# Rezoning Transportation Analysis

Petition Number: 2020-122

Date	Description
09-14-20	First Review (EL)
10-19-20	Second Review (EL)
11-30-2020	Third Review (EL)

RZ-1.0

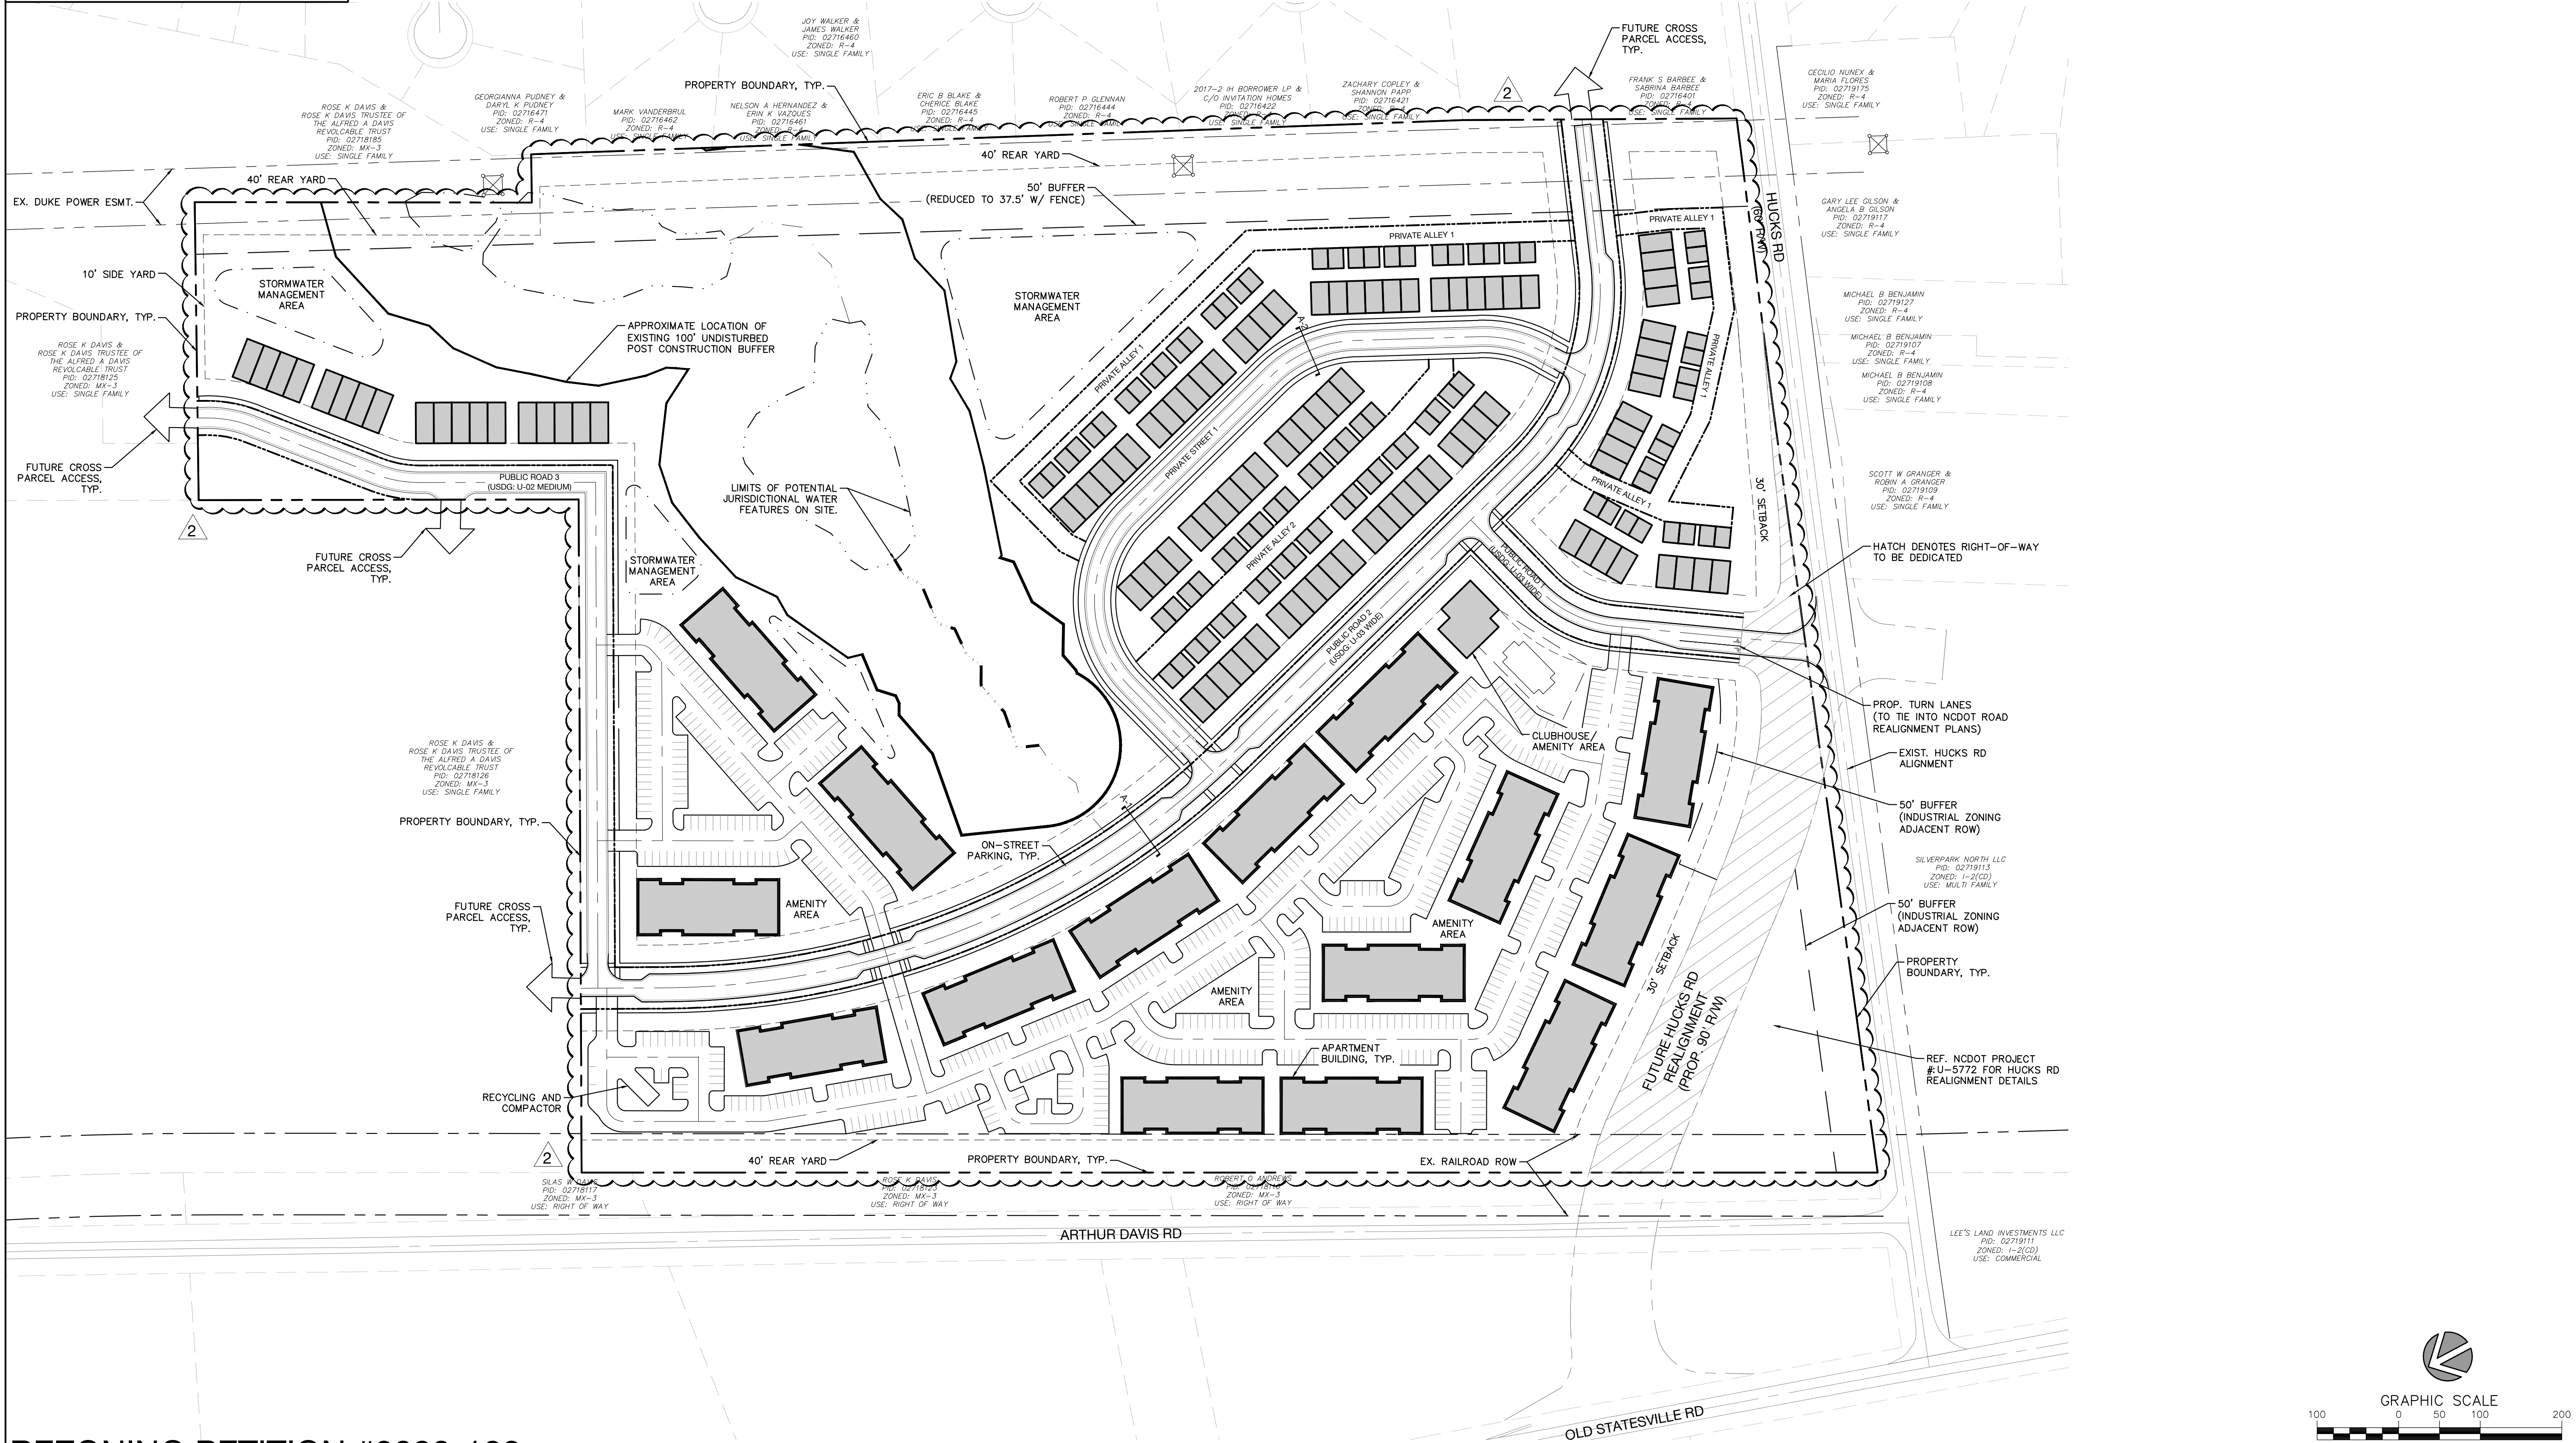
4. **Outstanding (site plan dated 10.12.20):** Revise the site plan and conditional note(s) to commit to construct the portion of Hucks Road Realignment that is graphically depicted on the site plan sheet **RZ-1.0**, to match the approved TIS scope.
